2024/90235 (condition 10)

2024/90236 (condition 11, 12 & 14)

2024/90237 (condition 03, 04, 05, 06, 07, 09 & 18)

04 BOUNDARY TREATMENT - ADJACENT NORTHERN TRACK SCALE 1:20

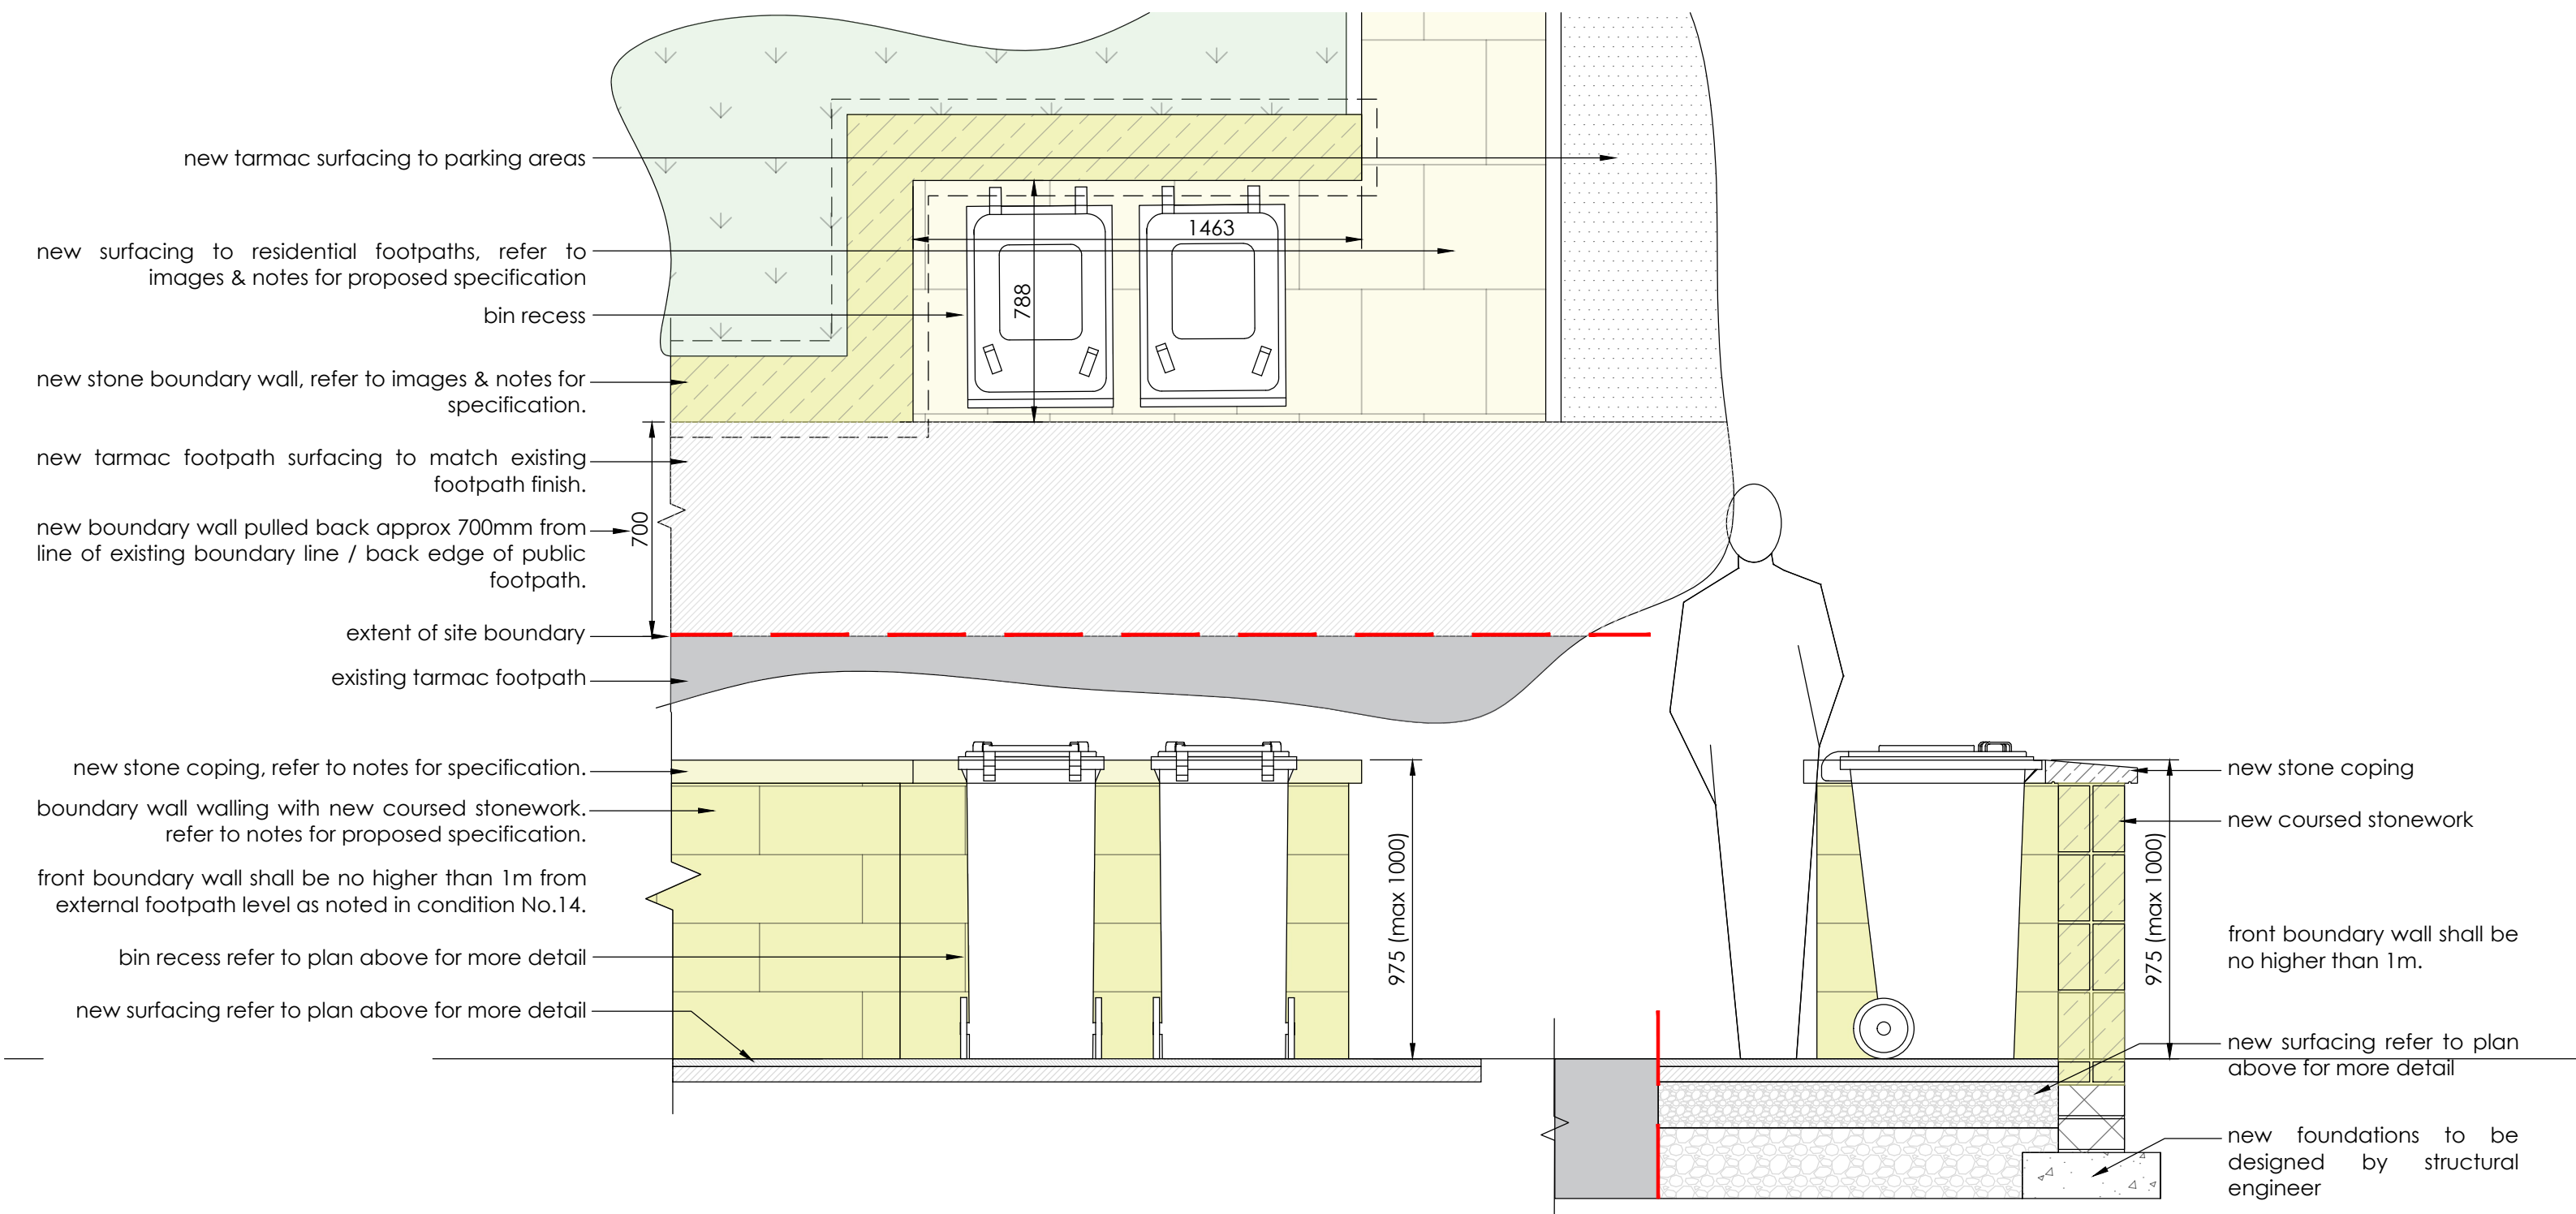
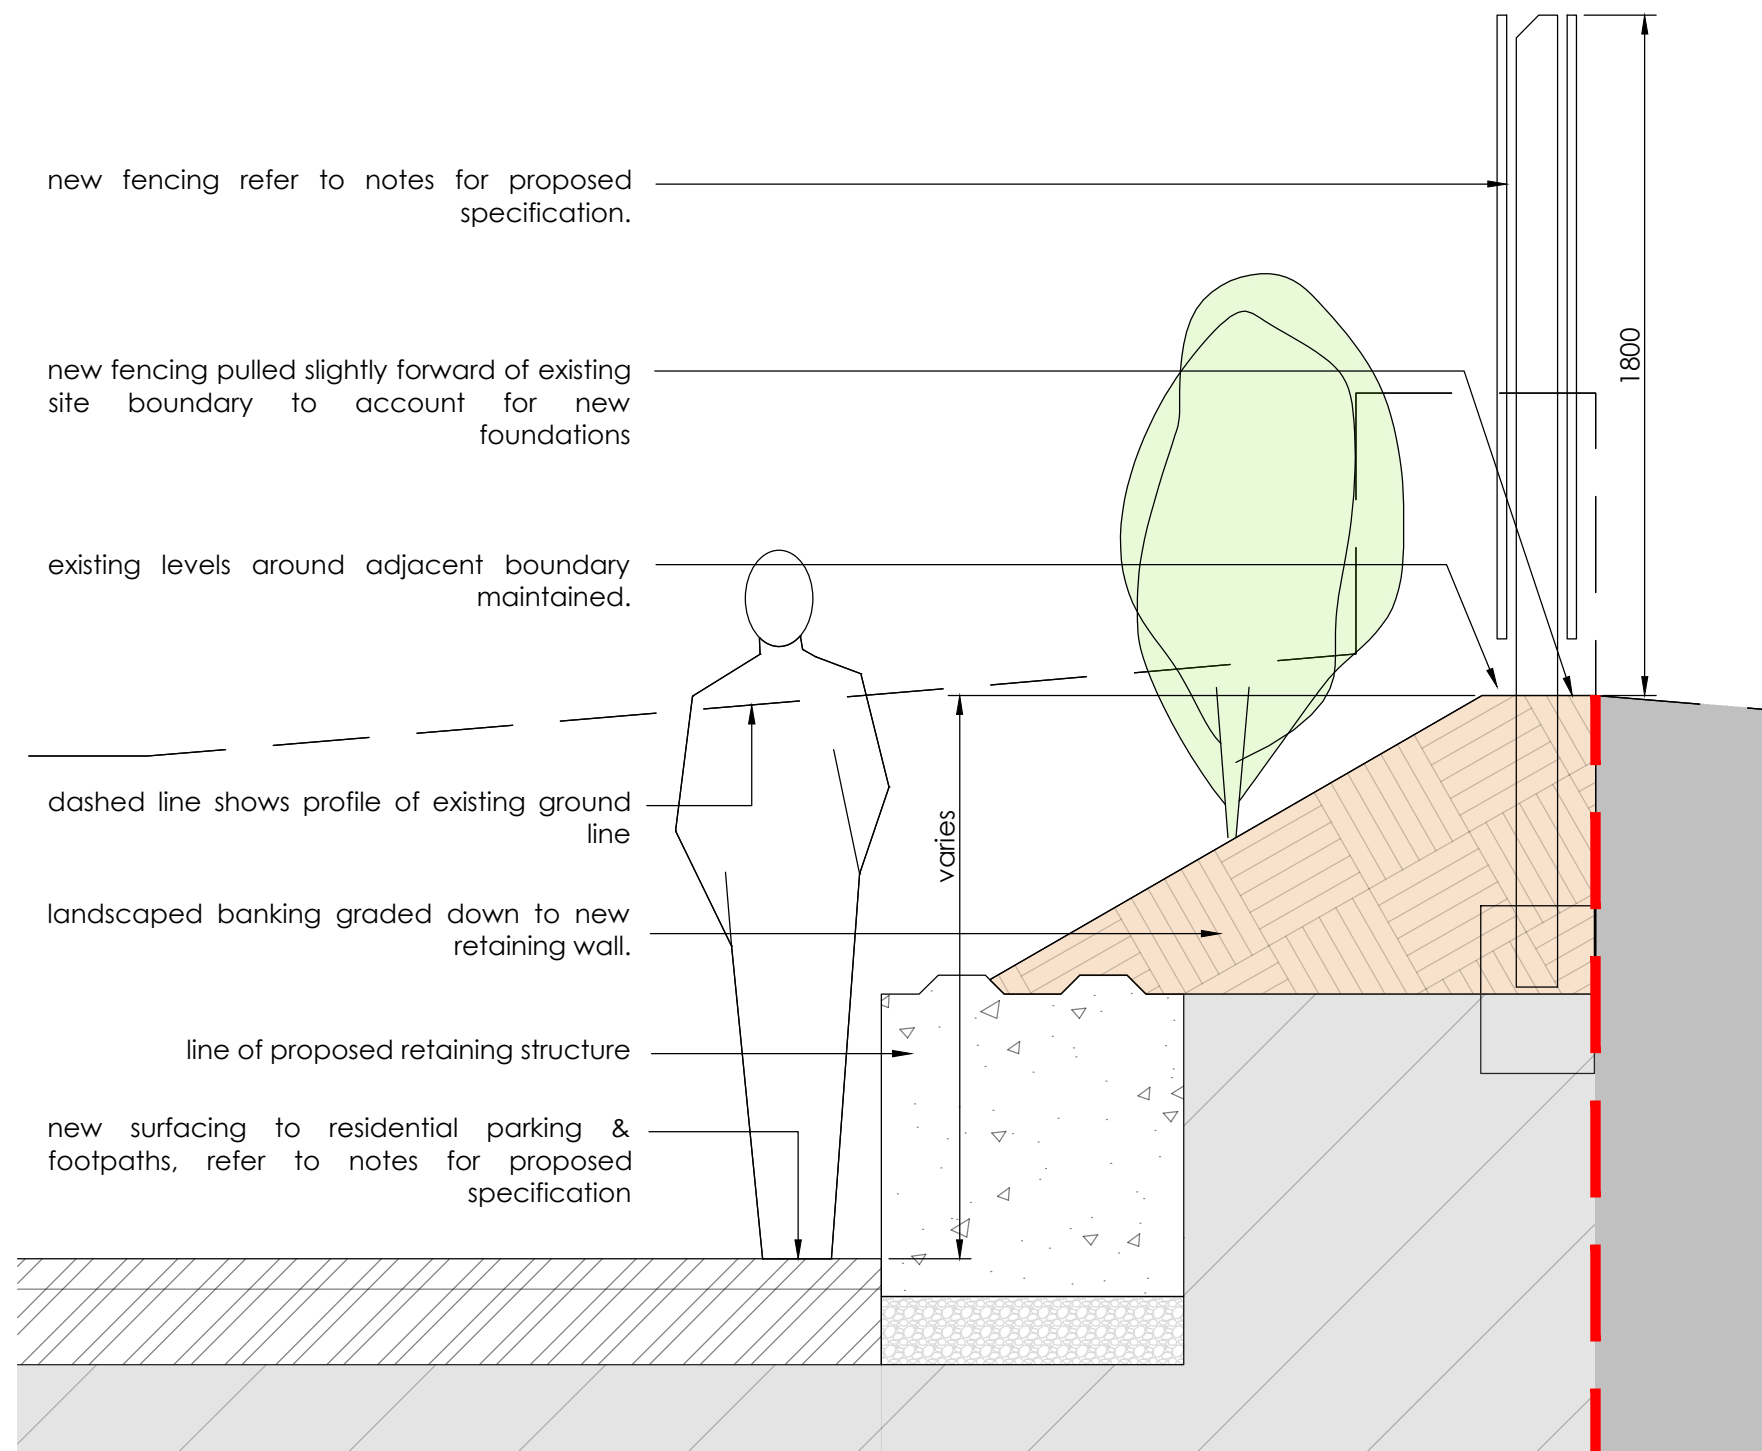
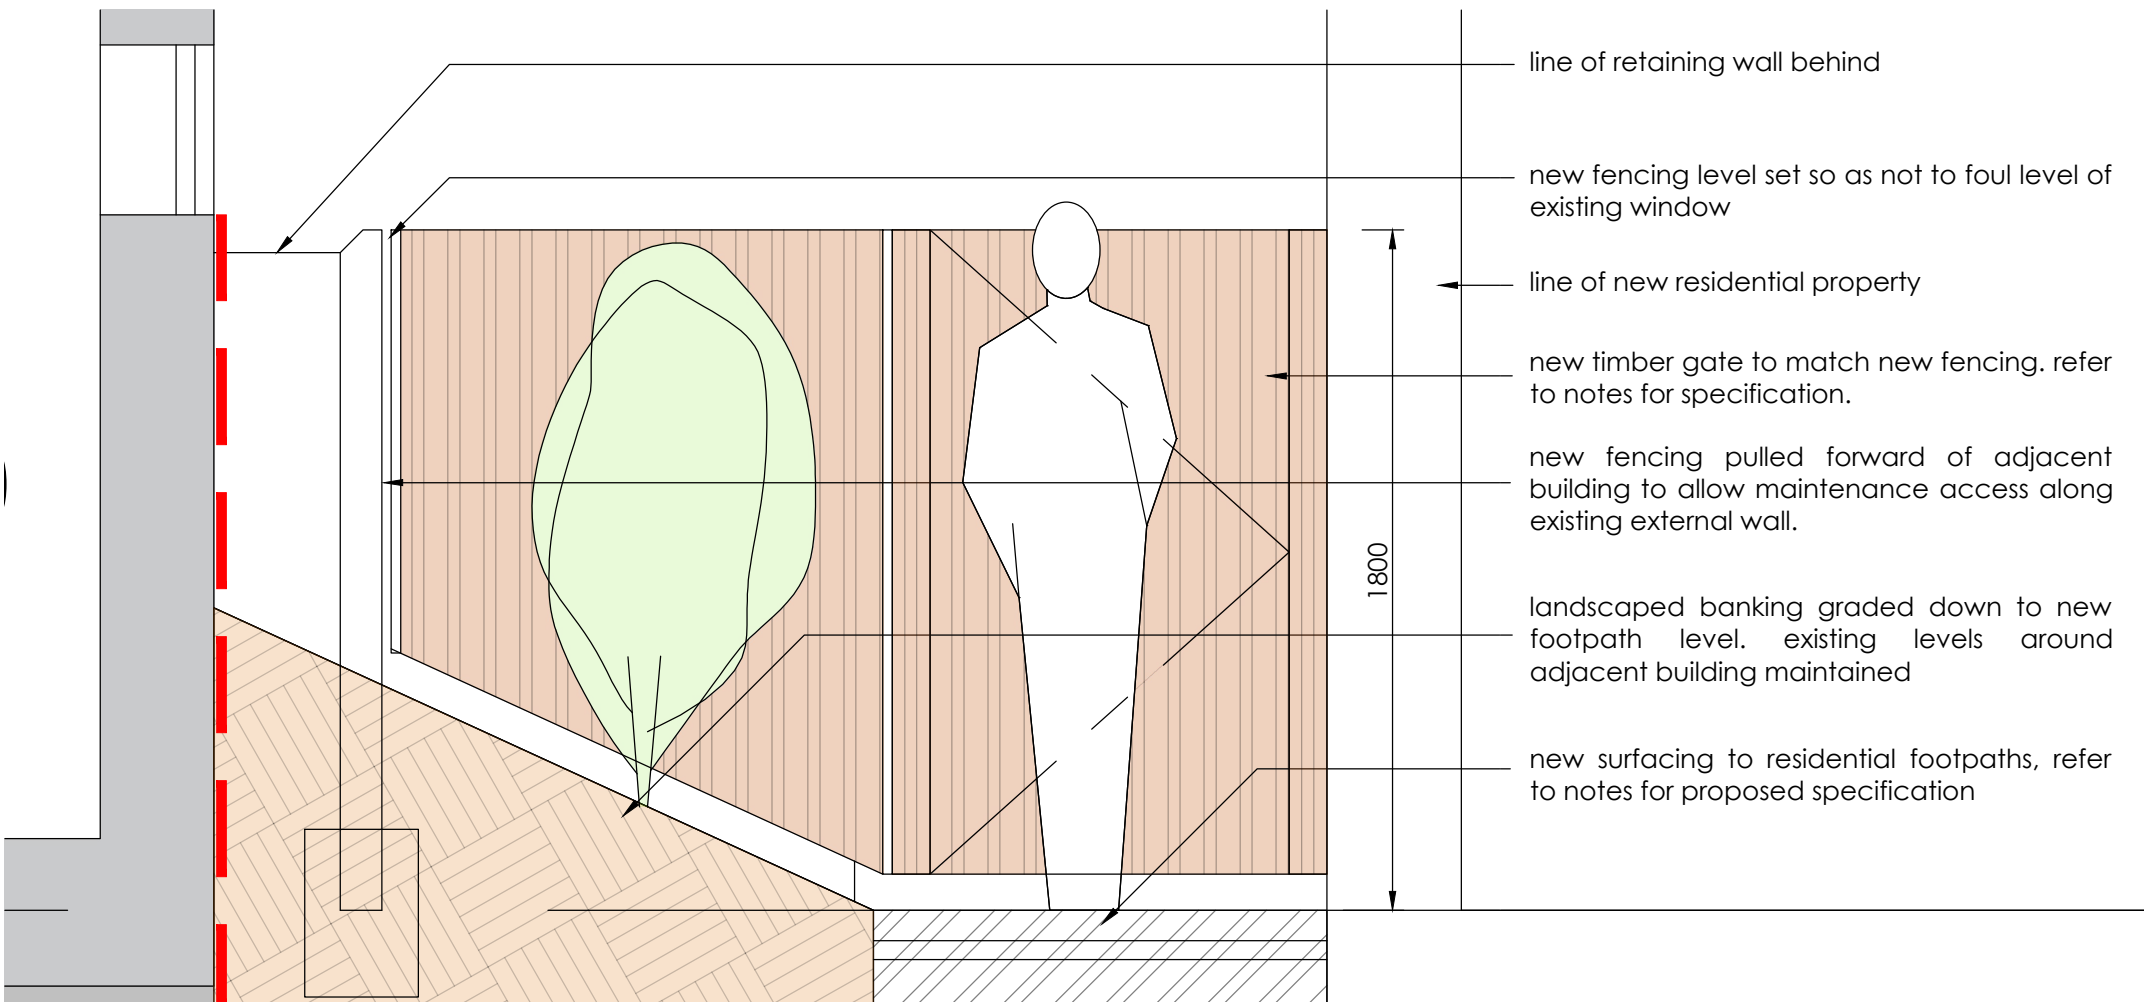
- *We also recommend the planning officer look at boundary treatments to the north which suggest a wall on some plans but a fence on others. A solid wall at the base is needed to deflect external flood routing down the track rather than onto site.*

- condition 10 (timescale: prior to above ground works commencing)
- please refer to the Appendix G – Condition 10: Drainage Addendum which has been prepared by GeoSmart to answer the above query.
- Please refer to detail 04 on drawing – 23-035/102 which shows an oversized continuous concrete gravel board is proposed at the base of the fence to direct water accordingly. the concrete gravel board presents a less permeable option than a masonry wall which has numerous mortar joints. For ease we have attached the detail 04 (Appendix H – Condition 10: boundary detail)
